City of Albuquerque Stormwater Construction Site Inspection Report

ESC File No.	C18E085	Project Name:	Allaso Olivine
NPDES Id. No.	NMR10059X & '5CC	Location:	6925 Alameda Blvd NE
1/17/2023	Owner	Contractor	
Operator	Titan Olivine, LLC	HB	
Contact name & title	Josh Rogers	Zach Gruen VP & Matthew Barnard SI	
e-mail	jrogers@titan-development.com	zachg@Hbconstruction.com & leer@	
Contact Phone #	505-998-0111	856-0404 & 250-2069	
COA Inspector	Doug Hughes	Start/End Time:	10:00 AM
Construction Phase:	framing/vertical		
Type of Inspection:		Storm Event	Past Storm Event >0.25" 311/Complaint Follow Up
Weather at time of inspection?	clear	Temperature:	~ 40
Estimated date of last storm 0.25" or greater	12/22/2023

CONCRETE WASHOUT AREA

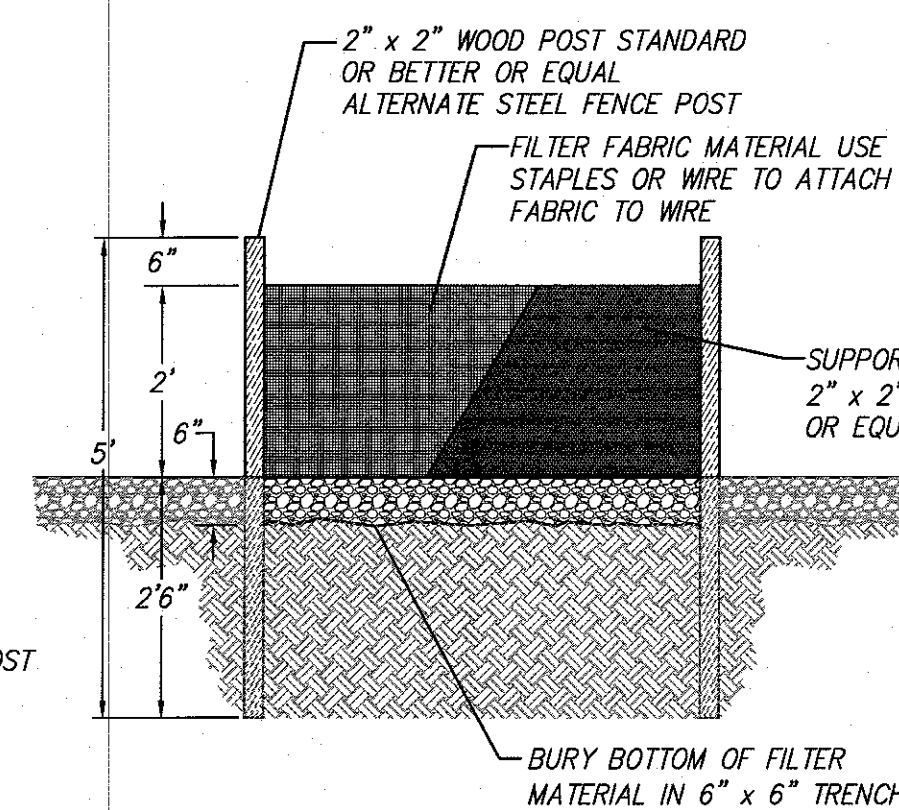
3	Washout was on bare dirt in several locations around the site and there weren't any lined washout facilities onsite. Required Mitigation. Remove and dispose contaminated soils and hardened concrete with other waste in per CGP 2.2.3. Direct all future wash water from concrete, paint, and stucco into a leak-proof container per CGP 2.3.4

SEDIMENT TRACK OUT CONTROL

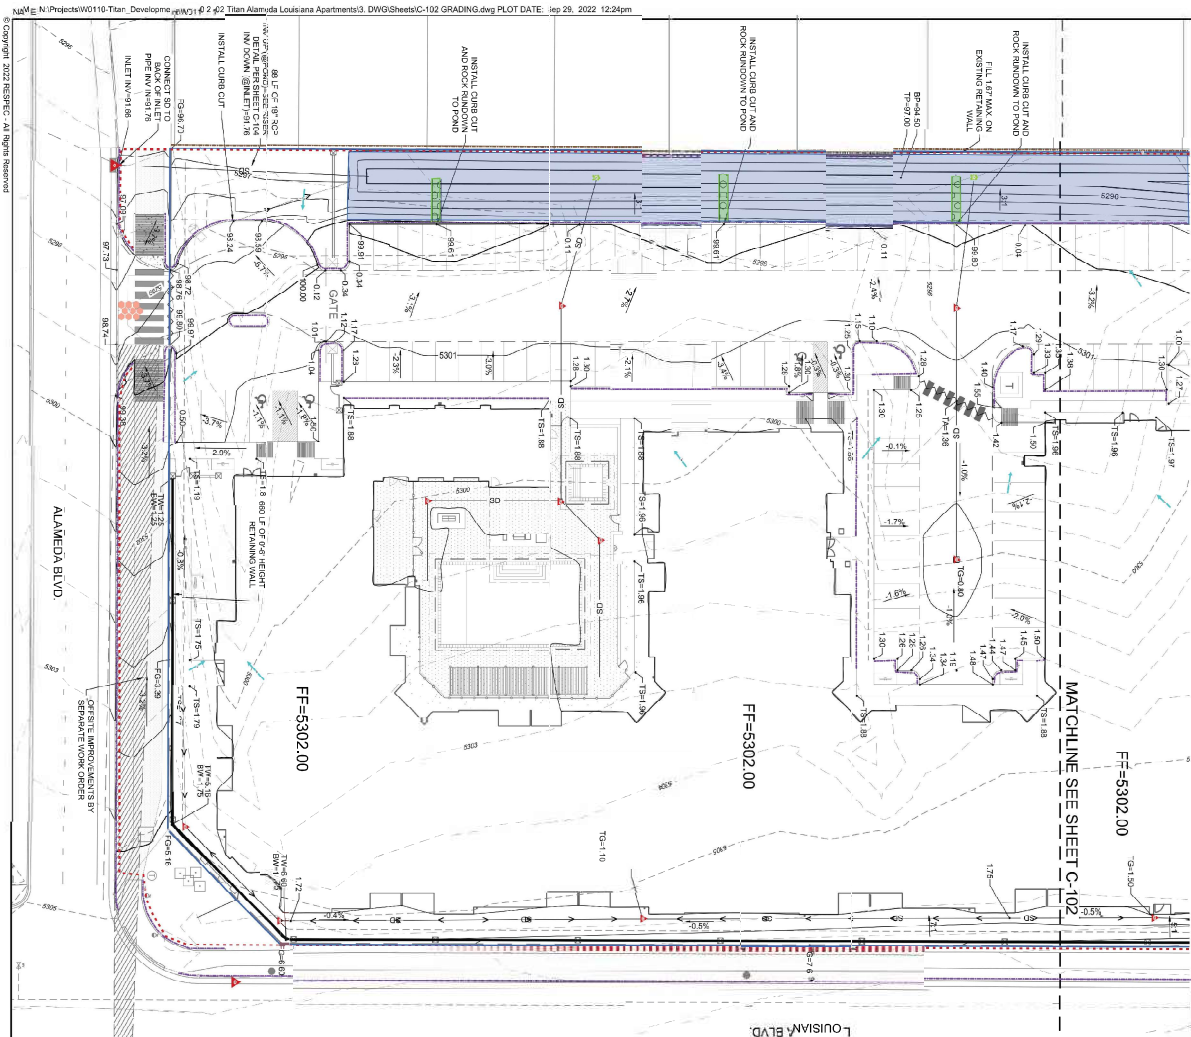
Item Number	Deficiency/ Corrective Action		
1	Sediment Trackout - sediment trails on Oakland and Louisiana between the lanes and the curb on both streets in Violation of CGP 2.2.4. Required Mitigation. Minimize sediment trackout per CGP 2.2.4. Implement additional track-out controls as necessary to ensure that sediment removal occurs prior to vehicle exit per CGP 2.2.4.c. Where sediment has been tracked-out from your site onto paved roads, sidewalks, or other paved areas outside of your site, remove the deposited sediment by the end of the same business day in which the track-out occurs or by the end of the next business day if track-out occurs on a non-business day. Remove the track-out by sweeping, shoveling, or vacuuming these surfaces, or by using other similarly effective means of sediment removal. You are prohibited from hosing or sweeping tracked-out per CGP 2.2.4.d		
2	SWPPP - The operators' signatures were missing from the inspection reports in violation of CGP Appendix G.11.2. Required Mitigation: The SWPPP, including the SWPPP Map, Self Inspection Reports, and Corrective Action Reports, must be kept up-to-date per CGP 7.1 and available on-site per CGP 4.7.3, 5.4.3 and 7.3. Your SWPPP, corrective action log, site inspection, and any other compliance documentation required under this permit, must be signed by the same responsible corporate officer that signs the certification statement on your NOI or by a duly authorized representative of that person per CGP Appendix G.11.2.
